Your Ref: OWQC21785
Our Ref: EP/22/19/PL
Please ask for:
Stuart Corbey

Town & Country Planning Act 1990 (as amended)
Town and Country Planning (Development Management Procedure) (England) Order 2015

New external walkaway with stair & ballstrade
78 Orchard Road East Preston

front (Orchard Road) proposed elevation (A1 1:100 A3 1:200)

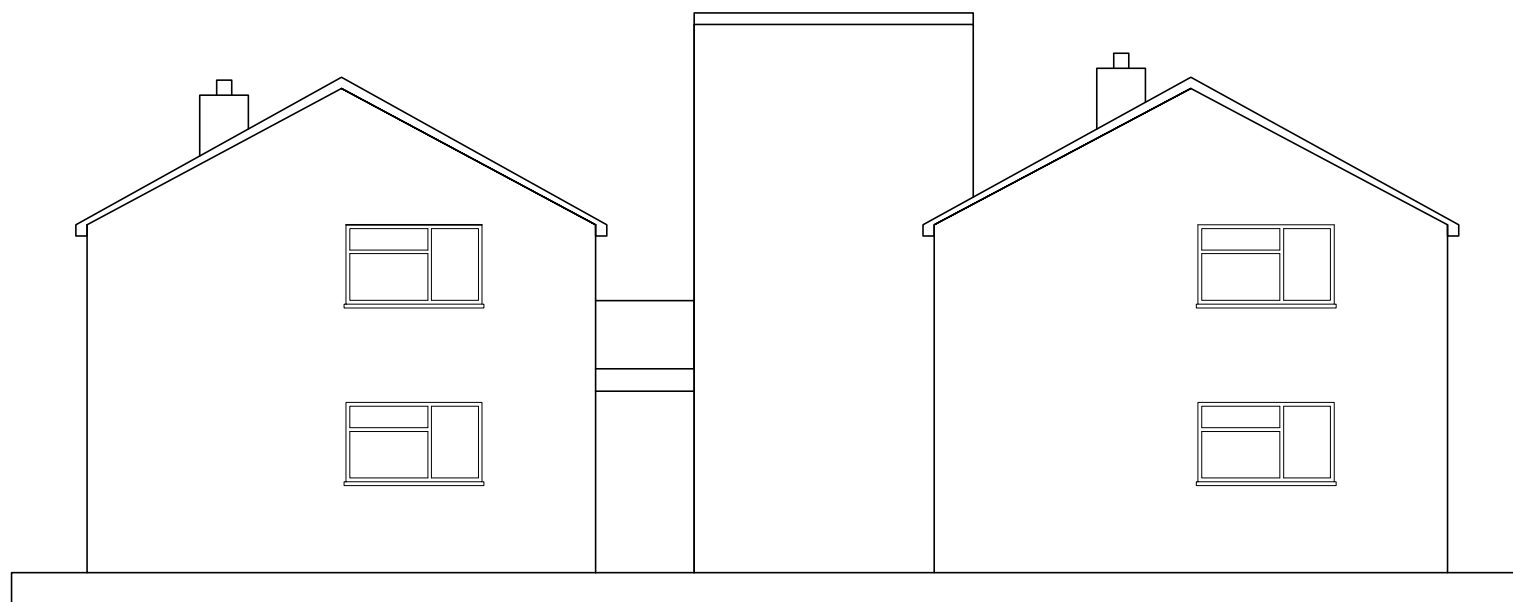
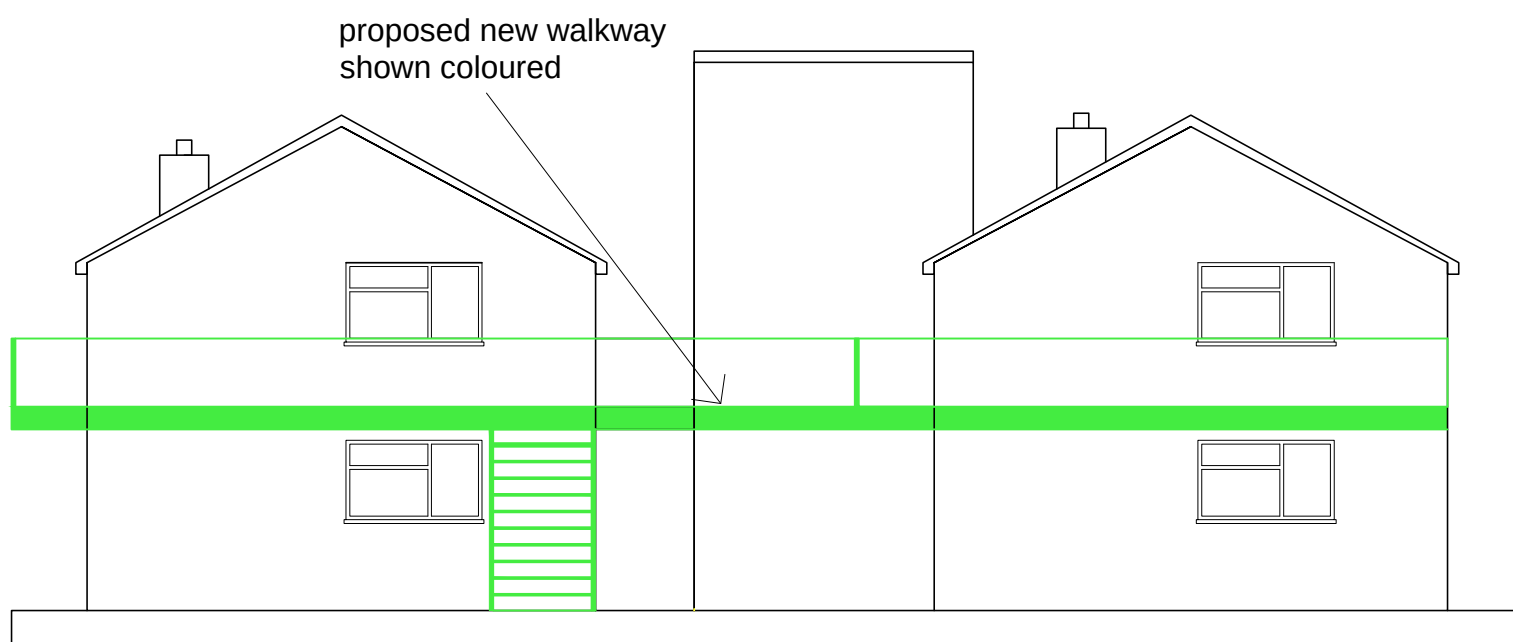
The committee agreed to object to this Application as it will change the existing streetscene. Although I have asked for some explanation of this change, I have received no such explanation. The lack of information provided with the Application for an ADC property is disappointing.
